**From:** Charles Wood [REDACTED]  
**Sent:** 03 February 2026 14:24  
**To:** Rhiannon Lloyd <Rhiannon.Lloyd@arun.gov.uk>  
**Cc:** Planning.Responses <Planning.Responses@arun.gov.uk>; Planning <Planning@arun.gov.uk>  
**Subject:** Objection to planning application M/98/25/HH

The following is my objection to certain parts of the planning permission **M/98/25/HH** which follows enforcement case **ENF/328/24** following refusal and dismissed appeal of **M/100/24/HH** which will support the document sent by the other immediate neighbours at 2 Elmer Court.

06 SIDE (EAST) ELEVATION:

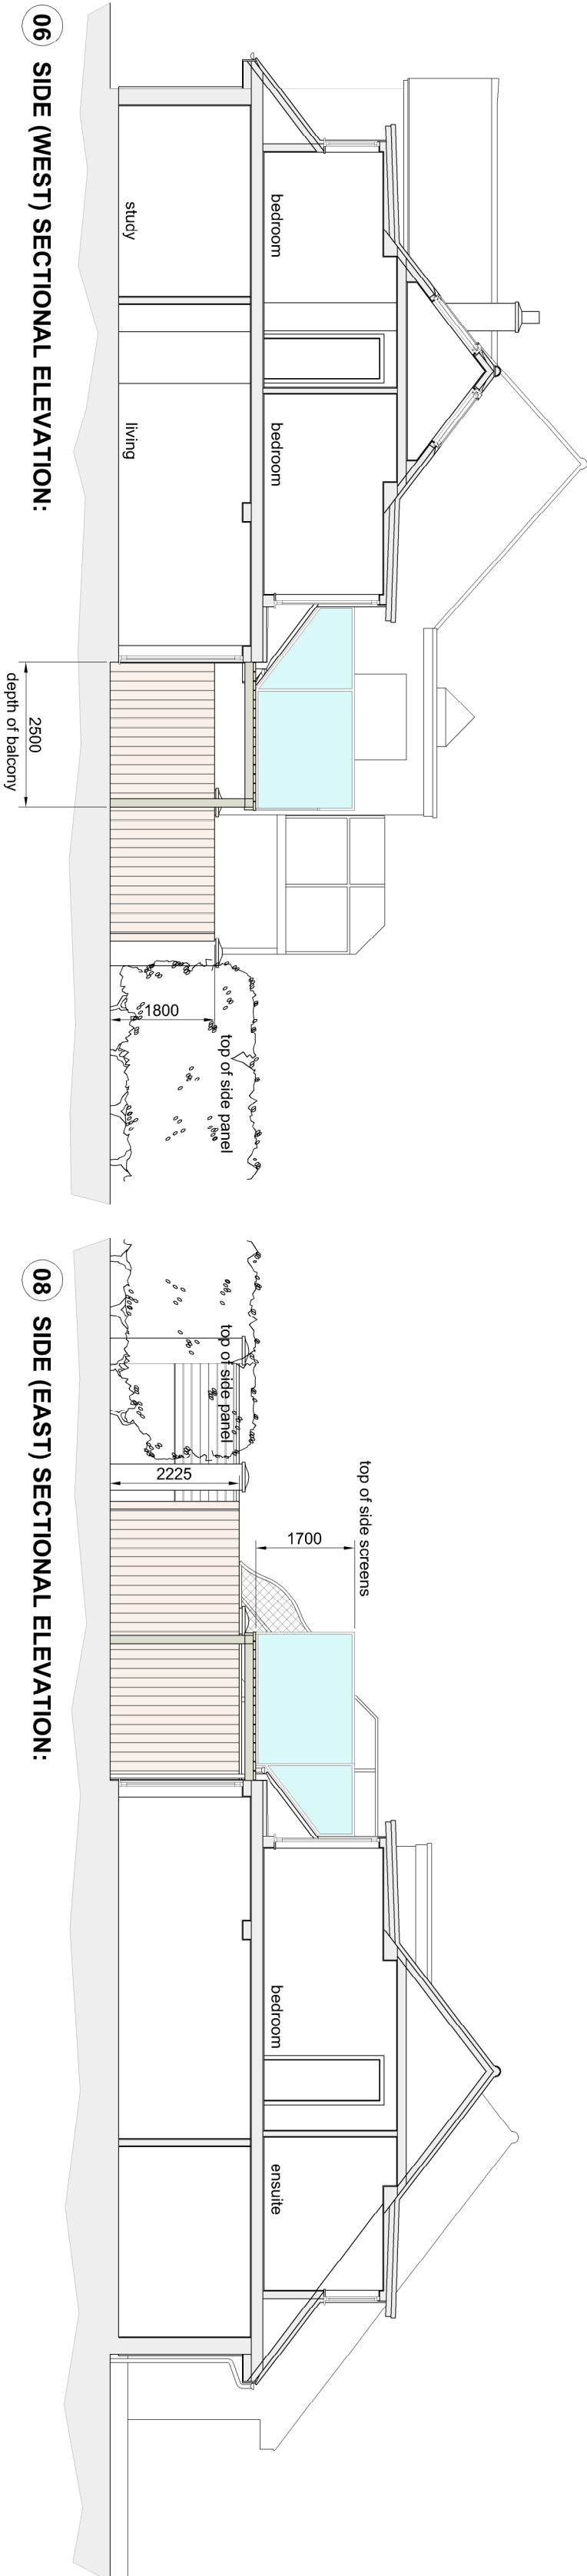
There are considerable inconsistencies in the stated width of the balcony in question and I cannot see in the plans that there is any intention to reduce this width from that which currently pertains and which was rejected by the council when a planning application was previously submitted.

However, the modified plans from the “2024 scheme” refused by Arun and dismissed on Appeal by the Inspector appointed by The Secretary of State, are minor and do not address the reasons for refusal. In fact, the width of the proposed balcony area is unchanged and its structure continuing to be the entire width of the applicant’s property (boundary to boundary) completely overwhelms the rear of the property contrary to Arun policy D DM1.

While it is to be welcomed that the depth of the so called “Pergola” extension has been reduced to a more acceptable level of 2500mm from the previously refused application, the width of the balcony adjoining both neighbouring properties remains unacceptable due to privacy (overlooking) and noise issues. This was one of a number of key reasons that Arun Council refused planning permission and the Planning Inspector dismissed the appeal, so therefore the proposed width (boundary to boundary) being unchanged remains unacceptable and contrary to the decision of the Planning Inspector.

In this case the gaps between No.4 The Hard, 1, Elmer Court and 2, Elmer Court are indeed “relatively small”, and as the balcony is at first floor level it fails the test, “*any extension or alteration at first floor level does not come to within a minimum of one metre of the side boundary*”.

In addition, the height including the substantial metal and glass side screens will be 4.50 meters built at the boundary maintaining overshadowing and overbearing as identified by the Arun Planning officer in their refusal and appeal dismissed by the planning Inspector.

It appears that to attempt to mitigate and overcome this restriction, the applicant is proposing obscured glass privacy screens. The installation of these screens is not a substitute to reducing the width of the balcony to no closer than 1 meter from the boundaries. By their nature, balconies encourage prolonged outdoor use at height, increasing noise levels and disturbance, particularly during evenings and weekends, to the detriment of neighbouring residents. Lack of privacy and considerable overlooking will remain at an unacceptable level. Users of the balcony will be directly overhead of the side garden of 4 The Hard eliminating the previous privacy this area enjoyed. Although these nuisances cannot be entirely eliminated, increasing the distance from the boundary is essential as the proposed 900mm “return” privacy panel to each side of the balcony is an entirely inadequate size to prevent close overlooking of neighbouring gardens

We therefore call for either refusal on basis of unchanged size of the balcony, or revised plans be submitted with the balcony set back from the boundaries. We respectfully suggest that the decision of the Inspector appointed by the Secretary of State should stand and not overruled as the proposed modifications do not meet their concerns or reason for the appeal dismissal.
